Re: Strole (BL-15-00009)

After conducting a review of the recent changes to the above named project, I have the following comments:

Stanavich / Strole Boundary Line Adjustment
 A PORTION OF SECTION 35,
 TOWNSHIP 19 NORTH, RANGE 18 EAST, W.M.
 KITTITAS COUNTY, WASHINGTON

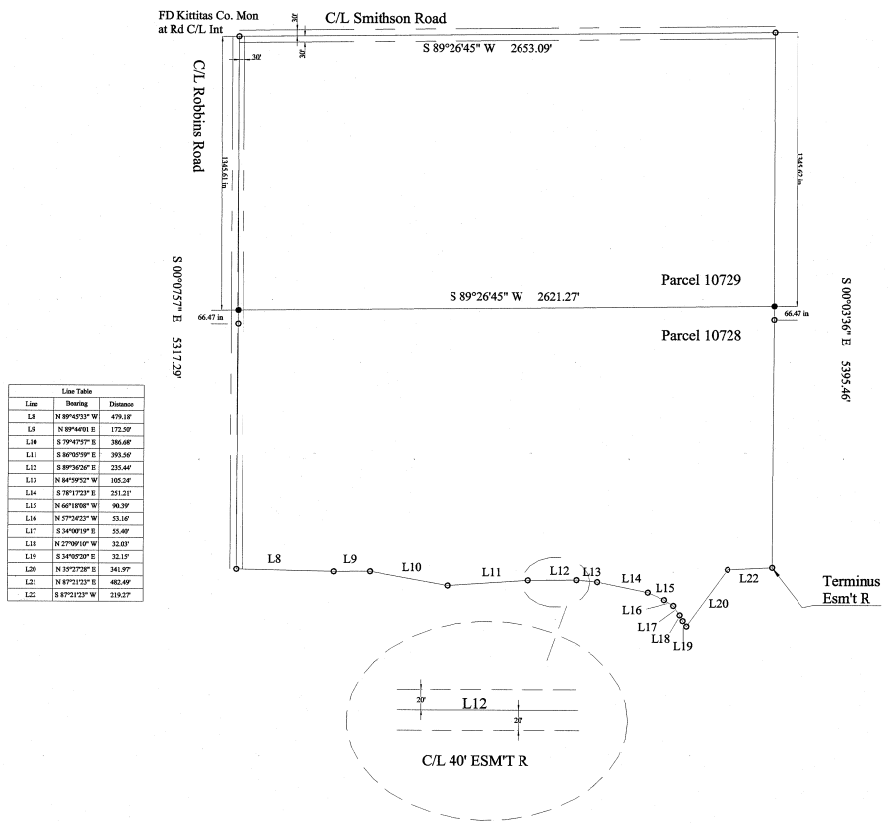
- Ensure that boundary line adjustments do not infringe upon existing structures, to include propane tanks, etc.
- Ensure adequate access for fire apparatus. Any driveways or access points created based off the new lot configurations shall comply with Kittitas County Code 20.02.030.
- All future development must comply with the International Fire Code.
